15 July 2022

REF: WTJ22 -024

RE: REPSONSE TO SUBMISSIONS - SSD-10371-MOD-1- REGULARISATION OF STUDENT NUMBERS

PROPERTY AT 119 PROSPECT ROAD AND 50-52 SEAVIEW STREET, SUMMER HILL

Figure 1

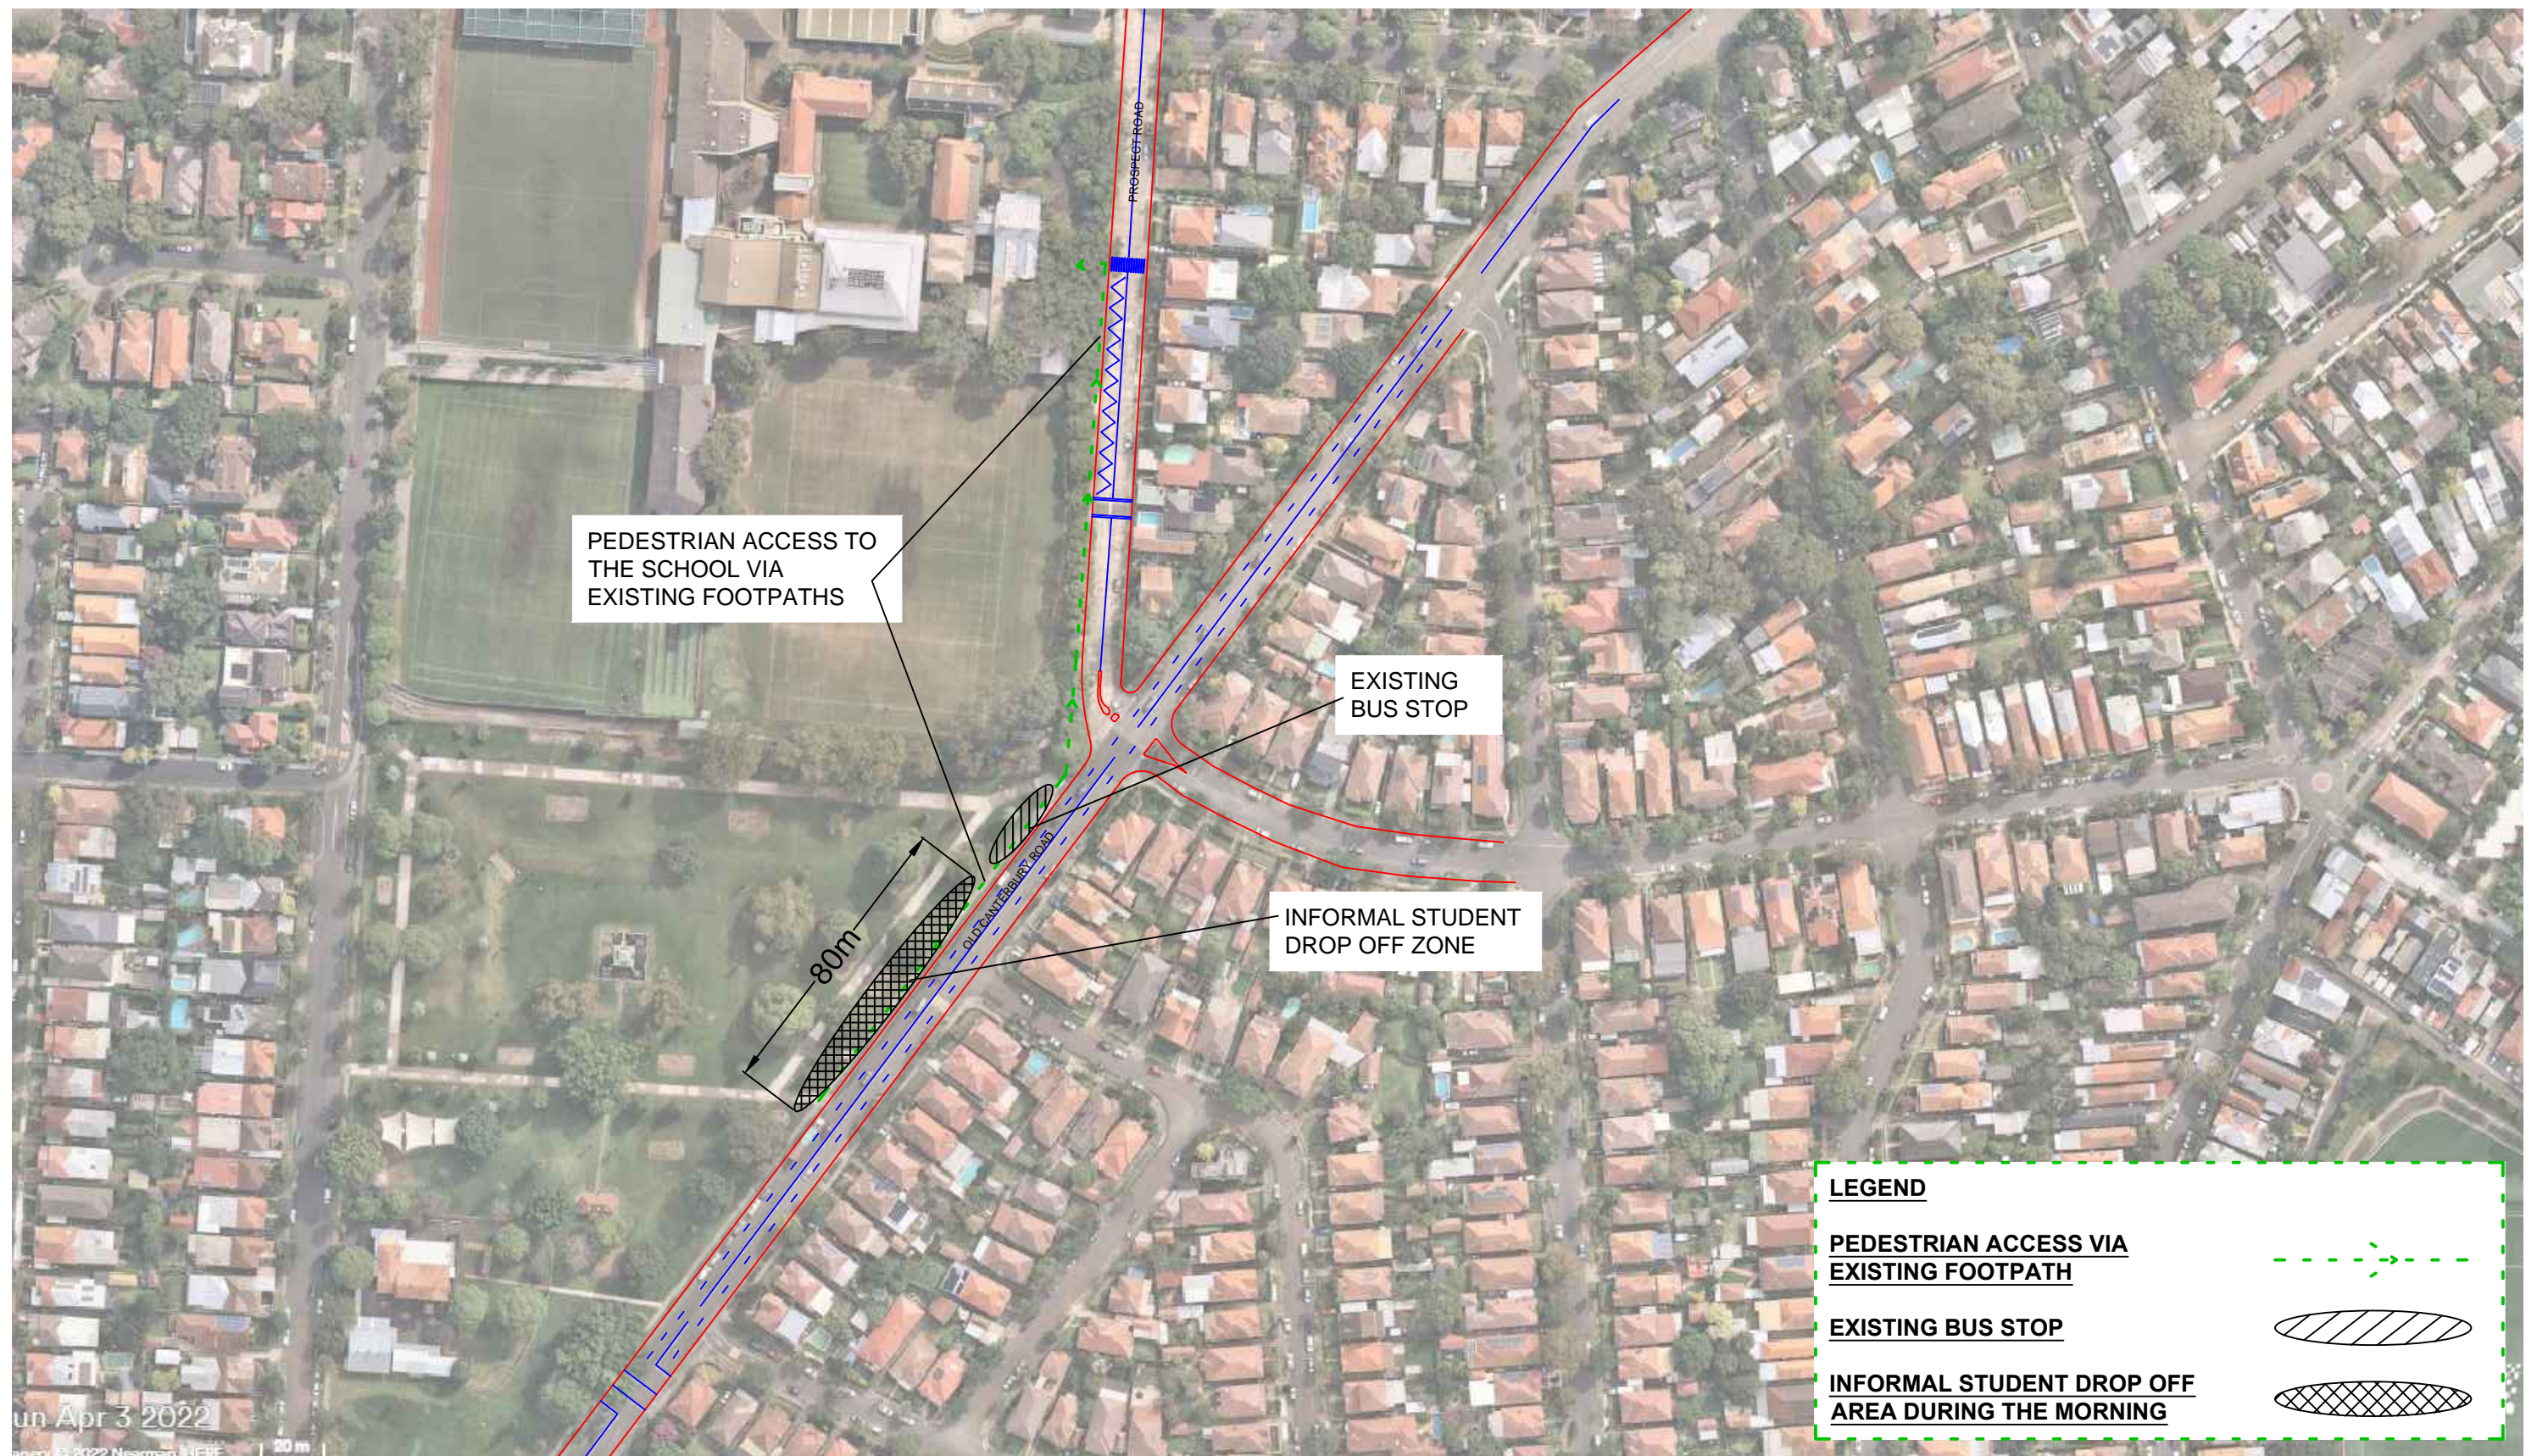
<p>You are requested to demonstrate how students would safely access the school site from the temporary DOPU zone on Old Canterbury Road.</p>	<p>An updated site plan of the temporary drop-off/pick-up zone has been provided in Appendix C</p>
<i>3. Prohibiting right turn out of the Jubilee car park</i>	
<p>You are requested to provide further information on the physical infrastructure, signage or traffic controlling staff, proposed to be in place to prohibit the right turn exit from the Jubilee car park.</p>	<p>As detailed in the Traffic Consultant Response letters at Appendix C, the following measures are in place to prohibit right turns out of the Jubilee car park:</p> <ul style="list-style-type: none"> • sign indicating left turn only (between 8am to 9am and 3pm to 5pm) • line marking on the exit lane indicating left turn only; and • a traffic marshal during the morning drop off and afternoon pick up periods directing traffic to turn left from the car park.

The proposed modification does not propose any changes to the number of parking spaces approved as part of SSD-10371. The proposed modification will however require the temporary removal of two parking spaces associated with the interim traffic measures during construction. These spaces are required to be temporarily removed.
